Further to our comments of 5th August 2025, updates can be found below in red.

Condition 6 – Construction Phase Flood Risk and Pollution Plan (temporary drainage).

Condition 16 – Attenuation, Flow Control and Maintenance & Management

Condition 17 – Northern Swale/Ditch

HYDROBRAKE DETAIL
NOT TO SCALE

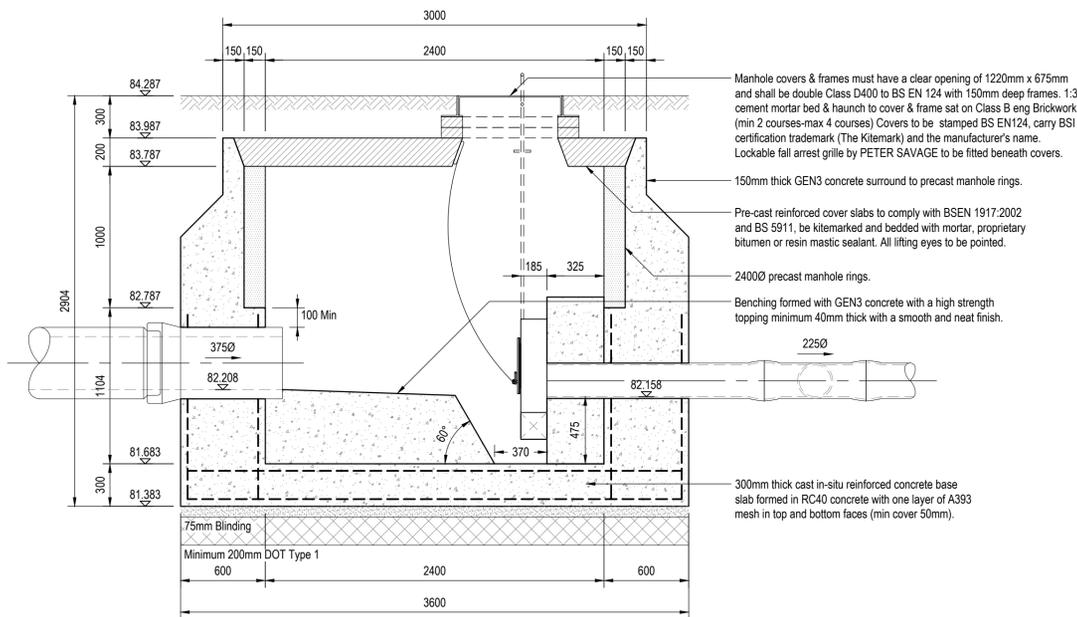
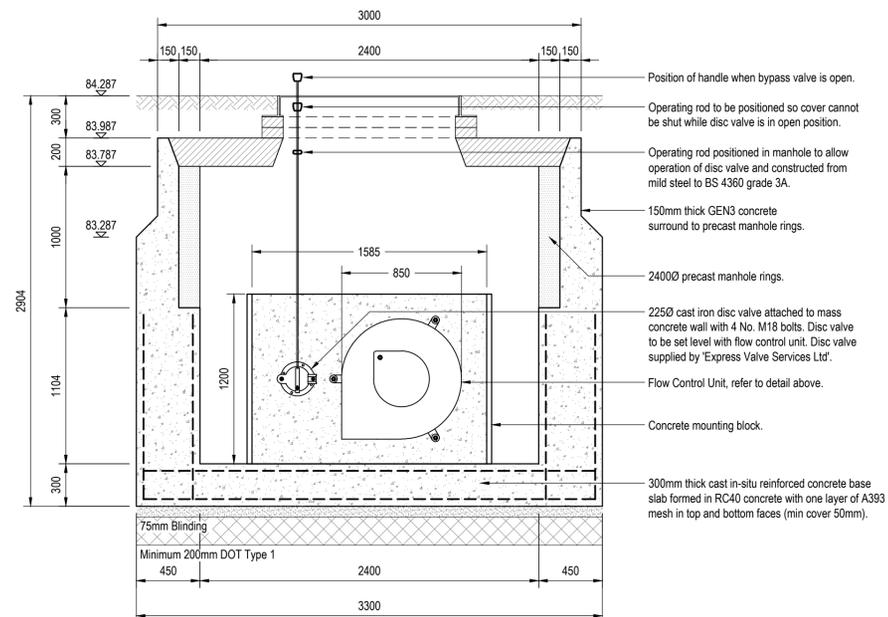
A flow control for the western drainage system has a 73mm orifice. The absolute minimum required of 75mm with a preference for 100mm to prevent blockages. The design must be revisited. **As stated above, this is unacceptable for phase 1.**

Please find attached email in relation to this condition requesting altered discharge rate to accommodate the increased orifice size
